Application No: EP/47/21/HH
Site Address: West House South Strand East Preston BN16 1PN
Description of works: Erection of second floor addition, part single storey side, part two storey front, side and rear extensions and alterations to fenestration/openings

Thank you for your internet representation made on 13th May 2021 which has been recorded as an objection with the comments as follows:

PR SF PLAN

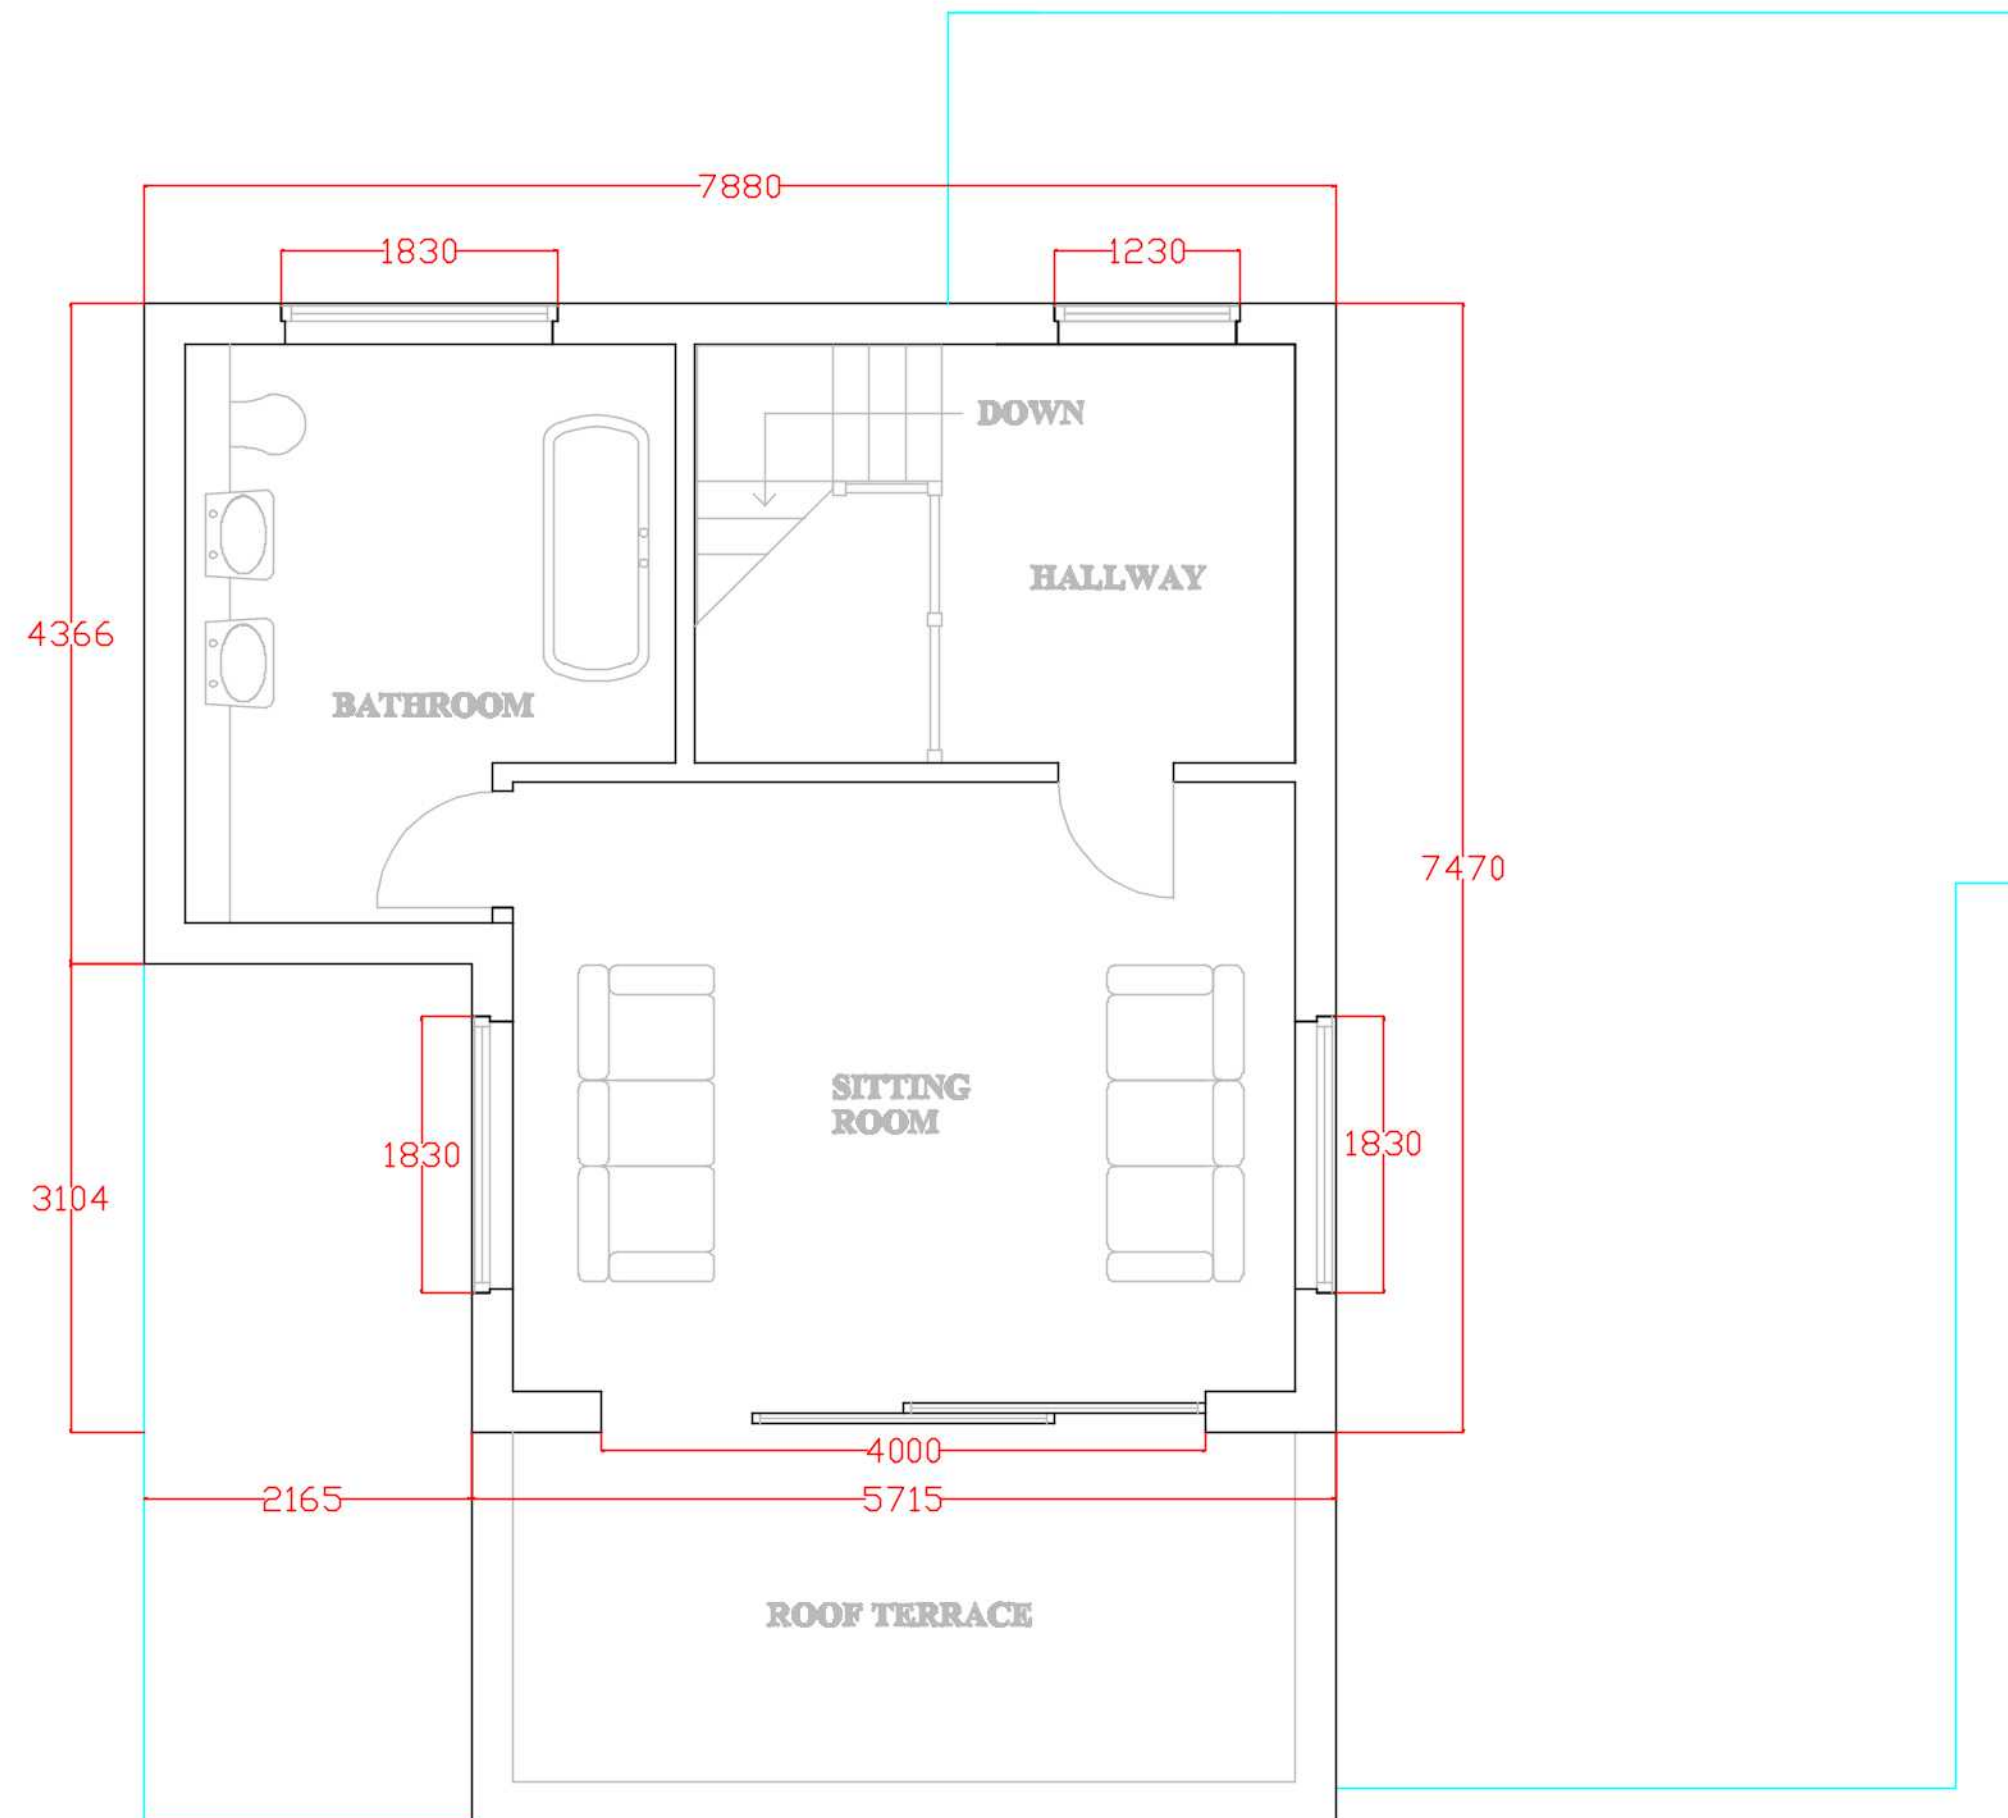
Our house is next door to West House.
The proposed 3rd floor addition is not acceptable as we will be overlooked and it would encroach on our privacy
The proposed plan is not in keeping with the rest of South Strand and the square box look is out of character.
